SUBJECT: New Hanover County, Smith Creek Pkwy US 117 Castle Hayne
Road to .5 mi. East of 23rd Street; Work Order Number
8.2250101; TIP Number U-92B

Attached is the modification of U. S. Army Corps of Engineers Permit Action No. 199603836 for the construction of the above referenced project.

Action ID No. 199603836 and TIP Project U-92AB, Smith Creek Parkway, New Hanover County, North Carolina.

Please reference the Department of the Army permit issued on December 12, 2000 for the subject project and your letters dated October 11, 2004 and December 10, 2004 (received February 1, 2005) requesting a permit modification at Wetland Site 3 of Section U-92B to authorize additional rip rap at the southeast corner of the 23rd street bridge, at STA Y3 20+23-22.00m LT.

PLAN VIEW SITE 3

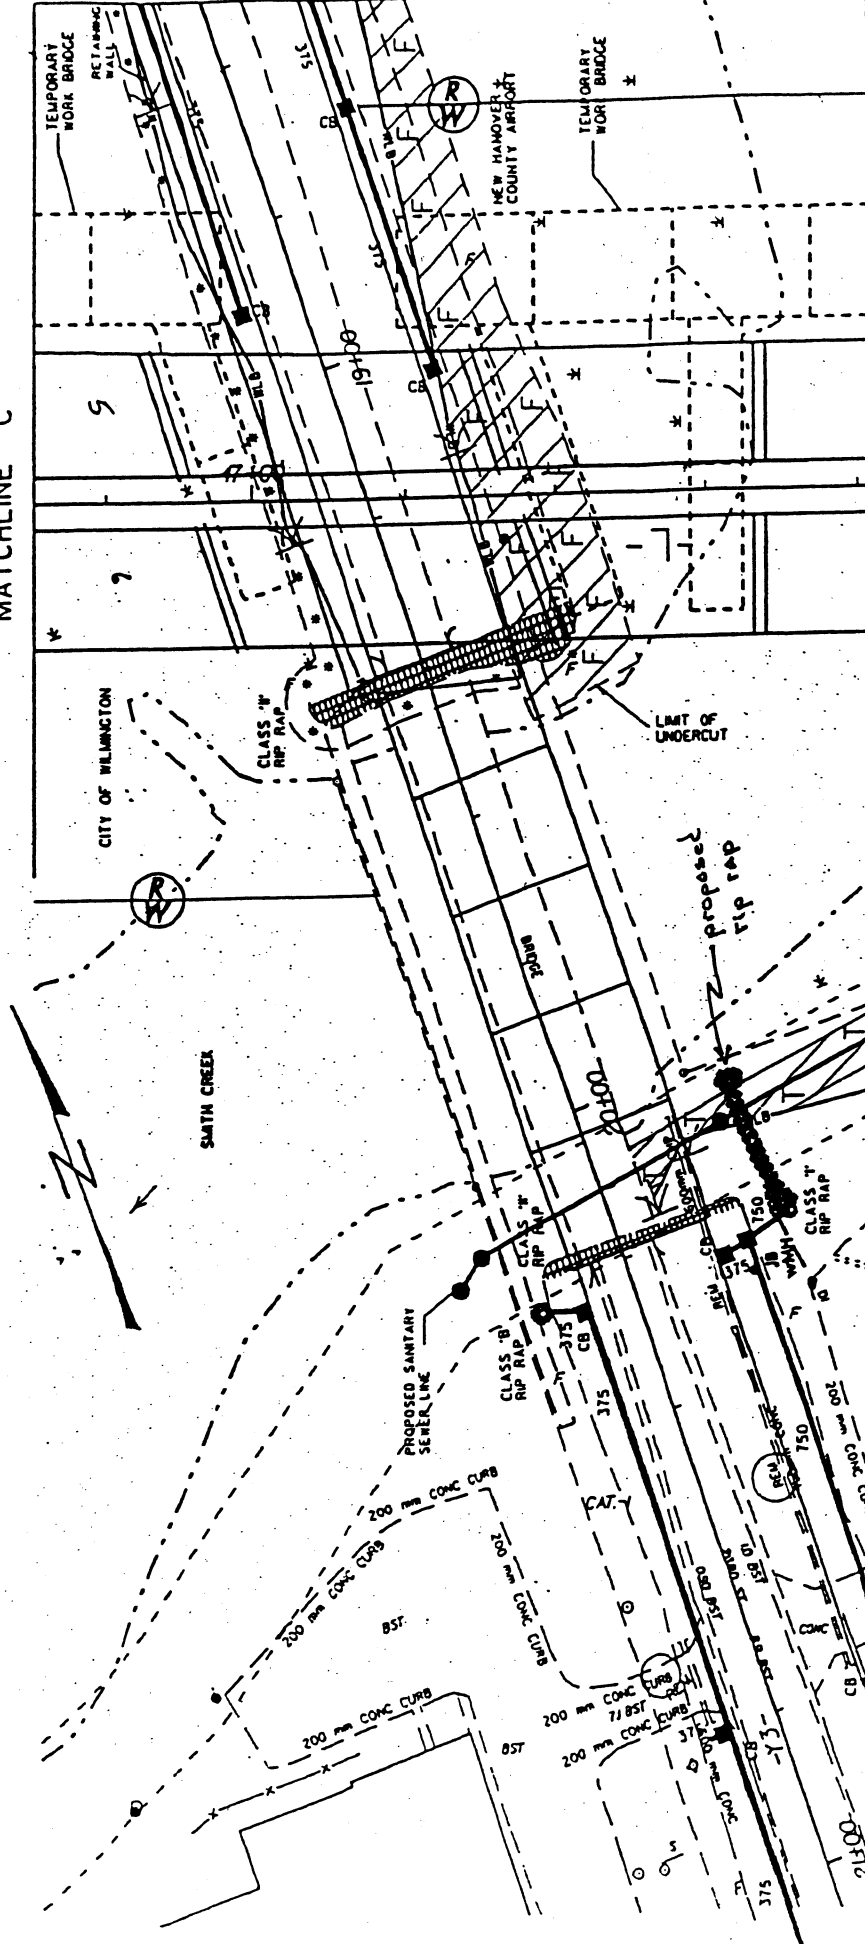
The original authorization allowed for a riprap apron that extended to the Mean High Water (MHW). Following construction, it was found that due to the steep grade at the outlet and heavy flow during rain events this riprap apron is inadequate for preventing slope erosion and associated elevated turbidity levels in Smith Creek. Therefore, you have requested a permit modification to construct a riprap flume below MHW that will extend 13 feet beyond the wetland boundary. The proposed modification will result in 0.003 acres (120 square feet) of permanent impacts to riverine wetlands of Smith Creek. To offset these wetland impacts you have proposed to provide 0.003 acres of on-site Coastal Small Stream Swamp restoration from a site located between the existing Bridge Maintenance Mitigation Site and Smith Creek Mitigation Site at STA 30+21-34+03m RT. This site was not included in the mitigation plans for this project but was restored to the same specifications as the Bridge Maintenance and Smith Creek mitigation sites during construction to connect these sites. The total area of restored riverine wetlands at this site is 0.17 acres.

Your DA permit is hereby modified to allow the additional riprap as shown in the revised permit drawing for Wetland Site 3 of U-92B dated 9-15-04 attached to your letter dated October 11, 2004 (copy attached) and the compensatory mitigation proposal attached to your letter dated December 10, 2004 (copy attached).
